Engineers Comments Regarding Surface Water Drainage

Application Reference:	AL/13/25/DOC	Reviewer Reference:	ADC/EXT2/D2134/70
Planning Officer:	Hannah Kersley	Date of Review:	12.09.2025
Site Name:	Karenza Hook Lane Aldingbourne PO20 3TB		
Application Description:	Approval of details reserved by condition imposed under reference AL/154/23/PL (APP/C3810/W/23/3335883) relating to condition number 3 - Construction Management Plan, condition number 5 - surface water drainage scheme, condition number 8 - external materials and finishes and condition number 9 - energy.		
Assessment Number:	2 of 2

Application Reference: AL/13/25/DOC Site Name: Karenza Hook Lane Aldingbourne PO20 3TB	Initial Issue Date: 29.04.2025 Issue Date: 12.09.2025 Reviewer Reference: ADC/EXT2/D2134/70
---	---

APPENDIX B

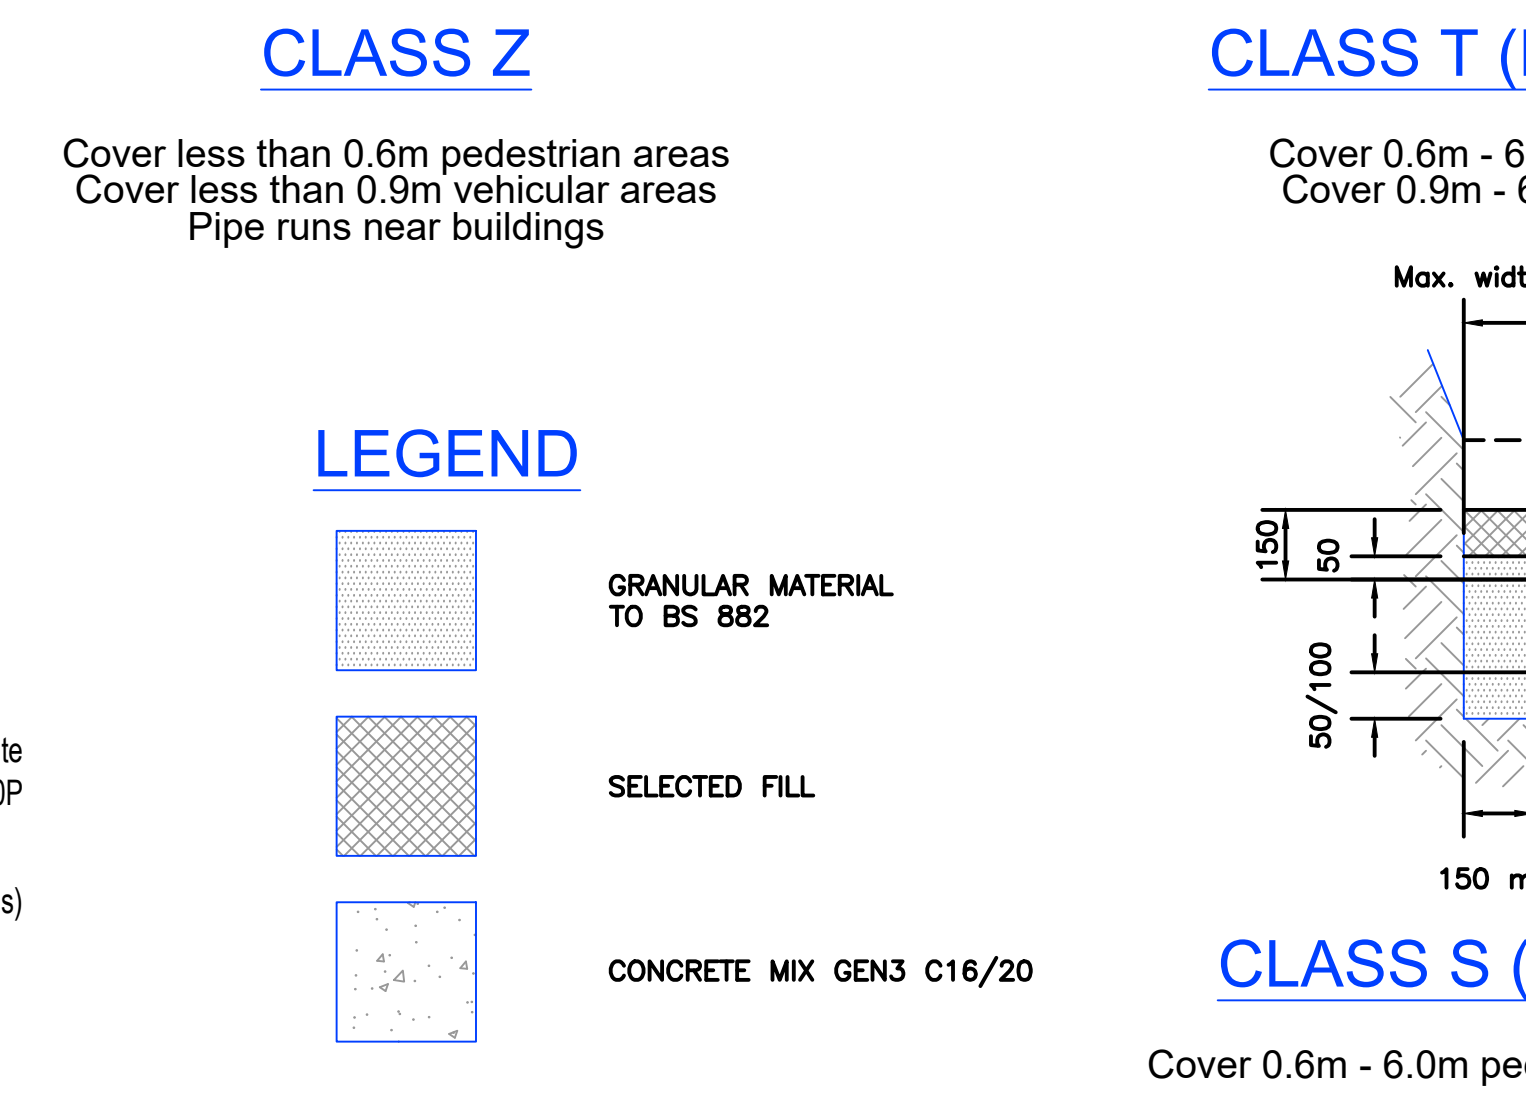
14.	The hydraulic calculations specify node SW-13 as a vortex flow control with an invert of 9.49m, however drawing 435050-221P2 shows this to be higher @ 9.494m. As cited above, for certainty the as-built levels must be used as they may not correlate with the phase 1 design.	Amended in the model	To clarify this is now SW-14 in the revised calcs with the correct invert. Comment closed.

20.	Drawing 435050-221P2 is very difficult to review where phase 1 is greyed out and the key does not clarify all items i.e. its is assumed the pink text represents the phase 1 formation levels?	The revised drawing is clearer and also the construction issue of phase 1 has now been provided	Comment closed.

21.	Drawing 435050-221P2 requires formation levels at all corners and at	This has been added	Comment closed.

25.	Please provide details of the foul drainage routing so this can be reviewed in conjunction with the surface water drainage.	Foul added on layout	Still missing on drainage GA drawing 221P. Comment outstanding.

26.	Please provide details of the main service routing/crossings so this can be reviewed in conjunction with the surface water drainage.	Service routings added on layout	Still missing on drainage GA drawing 221P. Comment outstanding.

30.	Drawing 435050-221P2 is very light on spot levels, no contours it is not possible to deduce where exceedance run-off will travel.	Exceedence flow layout provided in Appendix E	Comment closed.

35.			S12 orifice is noted as 35mm on the drainage GA drawing 221P and 45mm in the 1D model. Please advise the correct value, noting the National Standards recommendations for block risks.

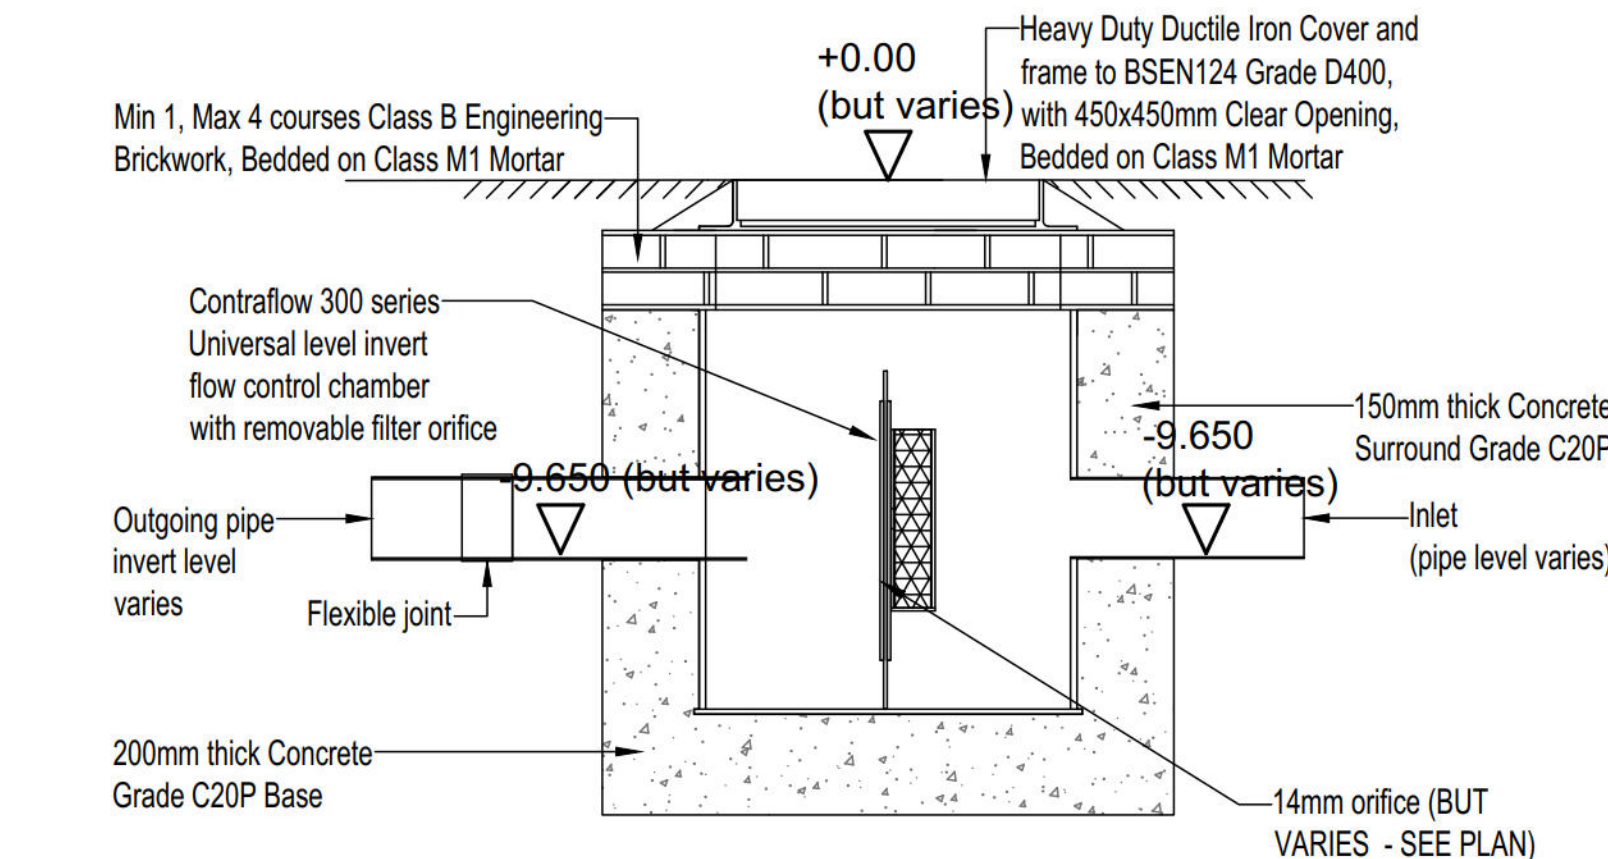
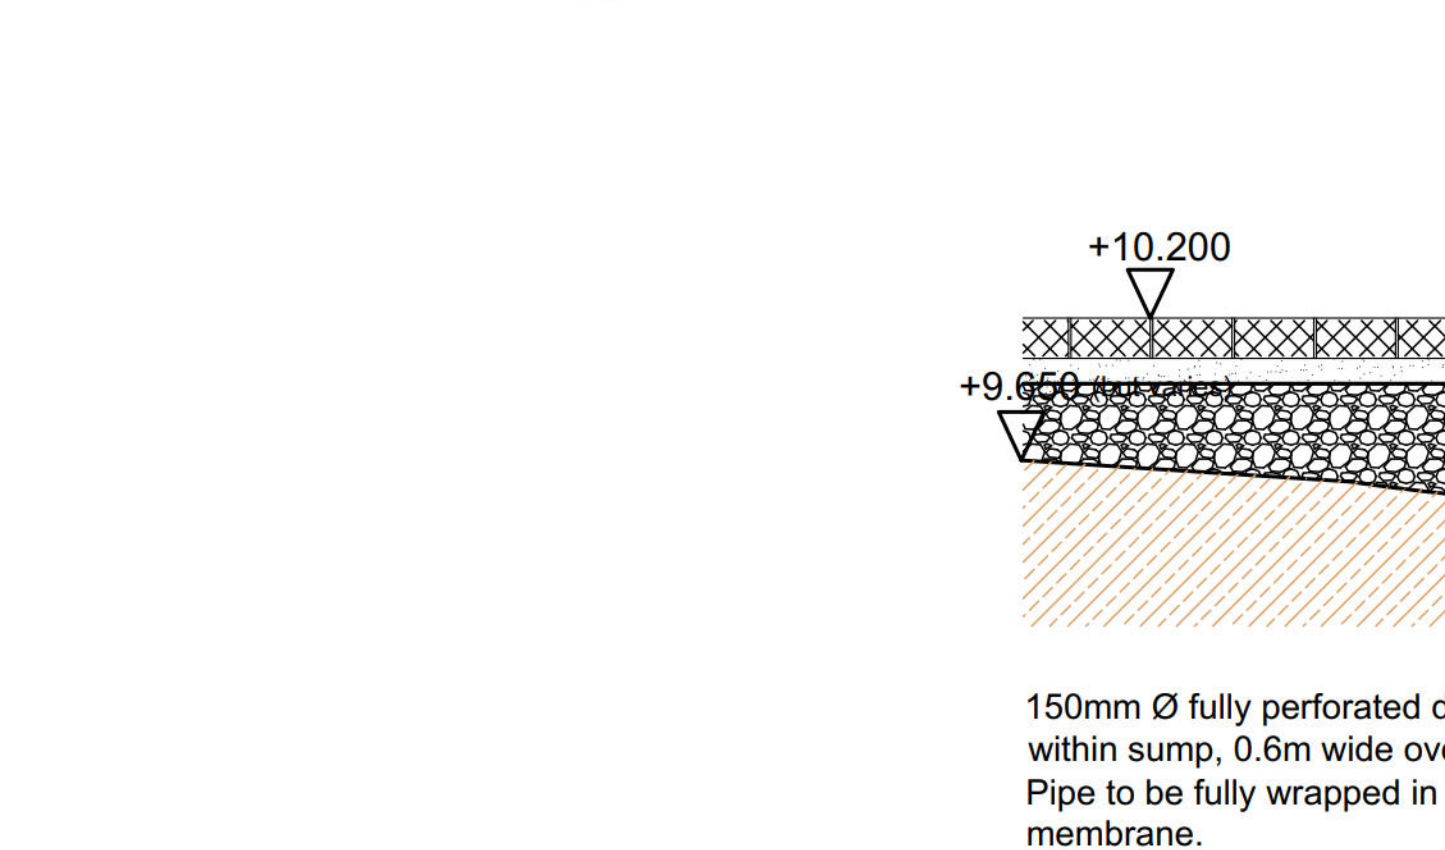
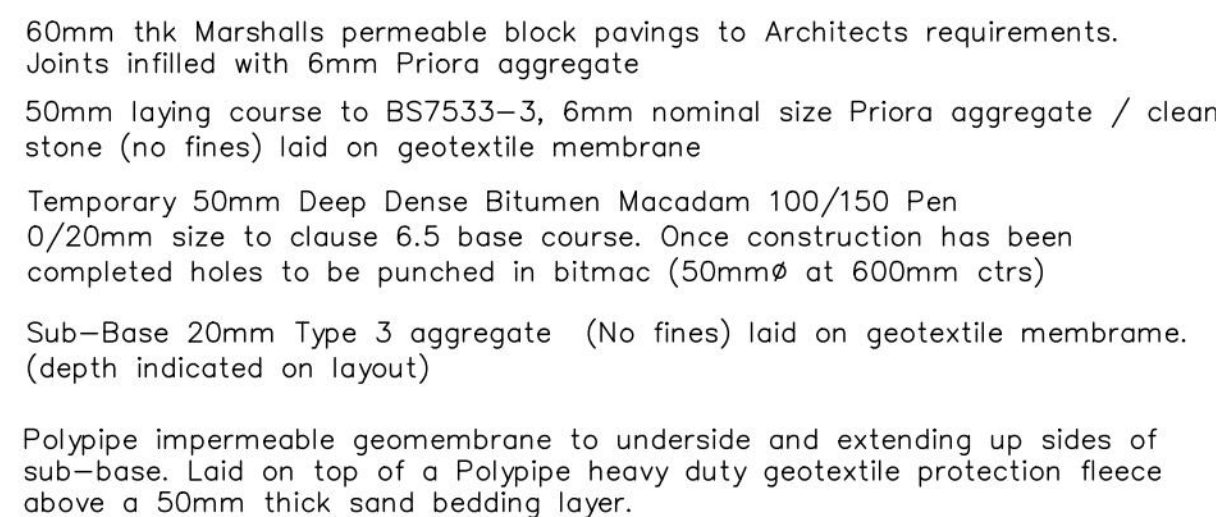
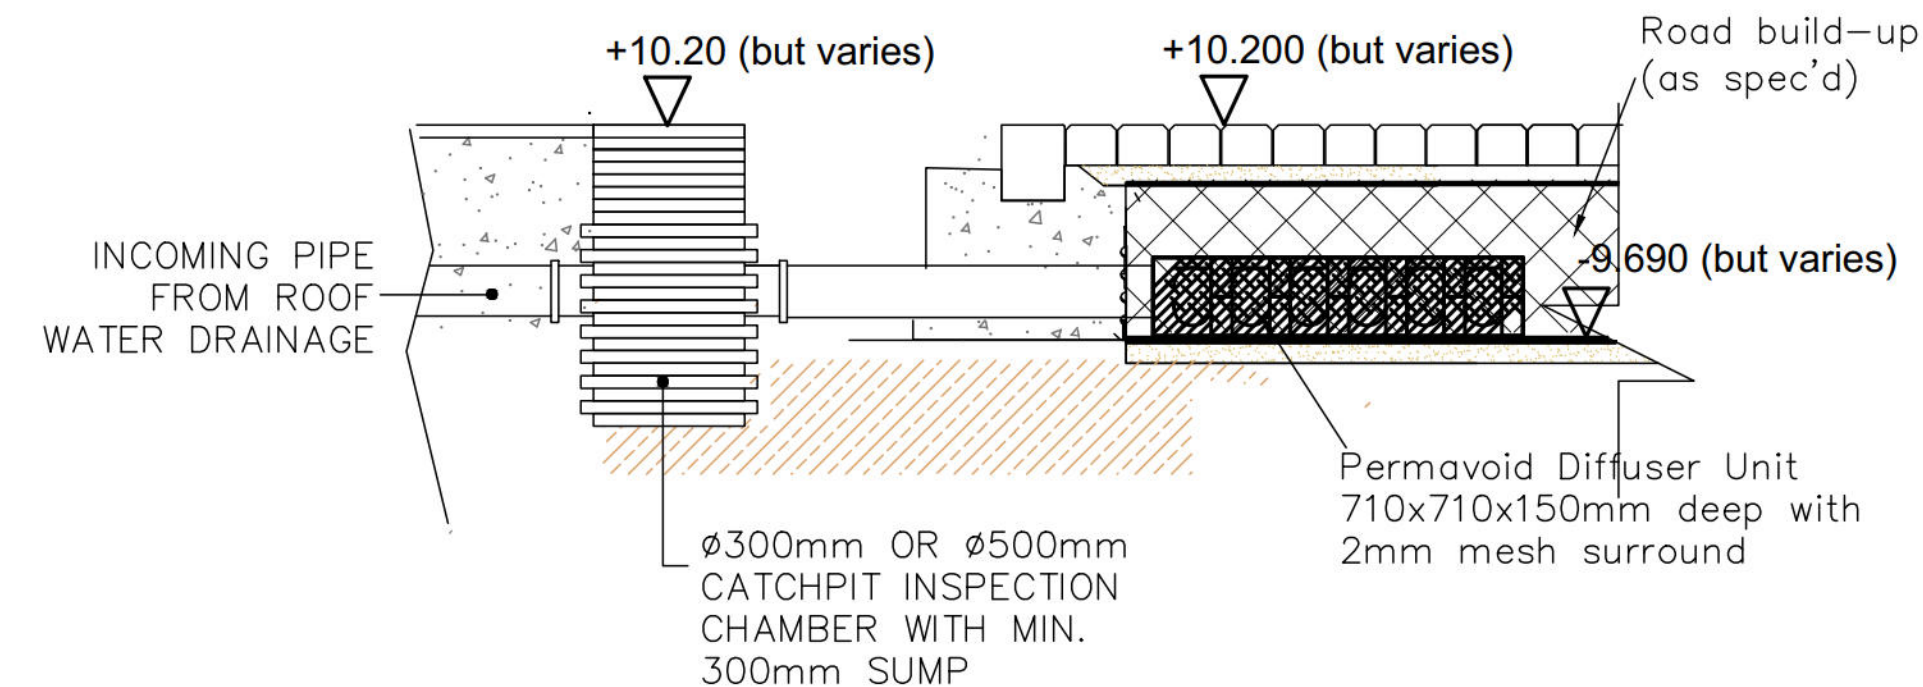
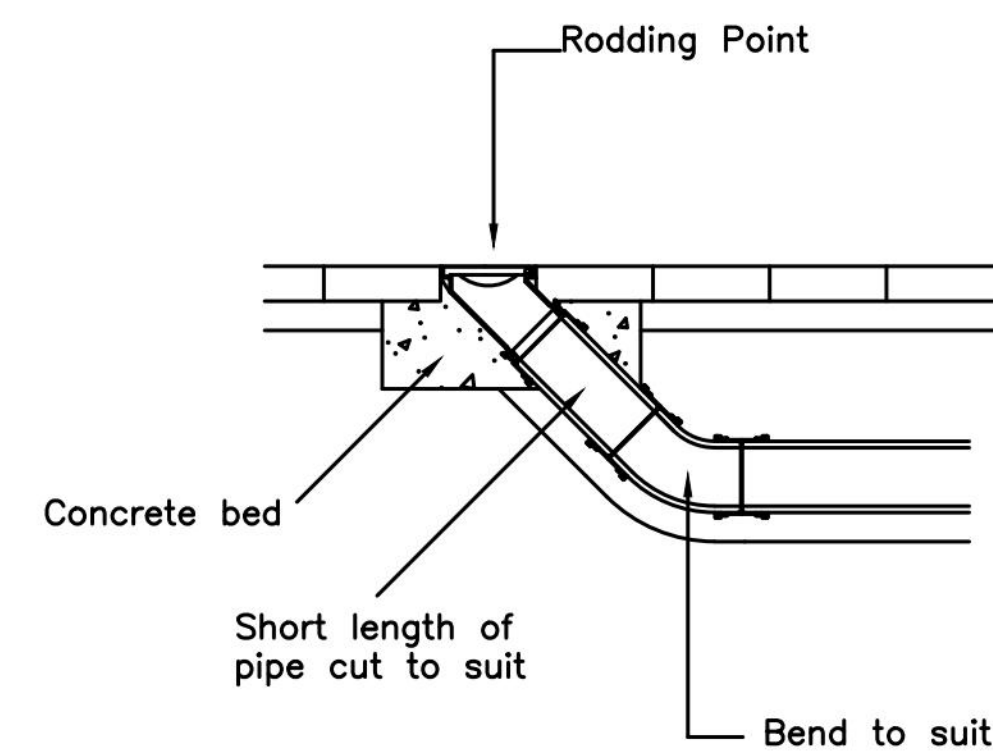
23.	Please provide construction details for all features identified on drawing 435050-221P2.	Detail provided on Drawing 435050-222P	Comment closed.		
24.	Measures to protect the permeable pavement (asphalt construction) during the construction period must be annotated on the drawings to ensure that it does not become silt up prior to completion of the project.	See details on drawing 435050-222P	Comment closed.
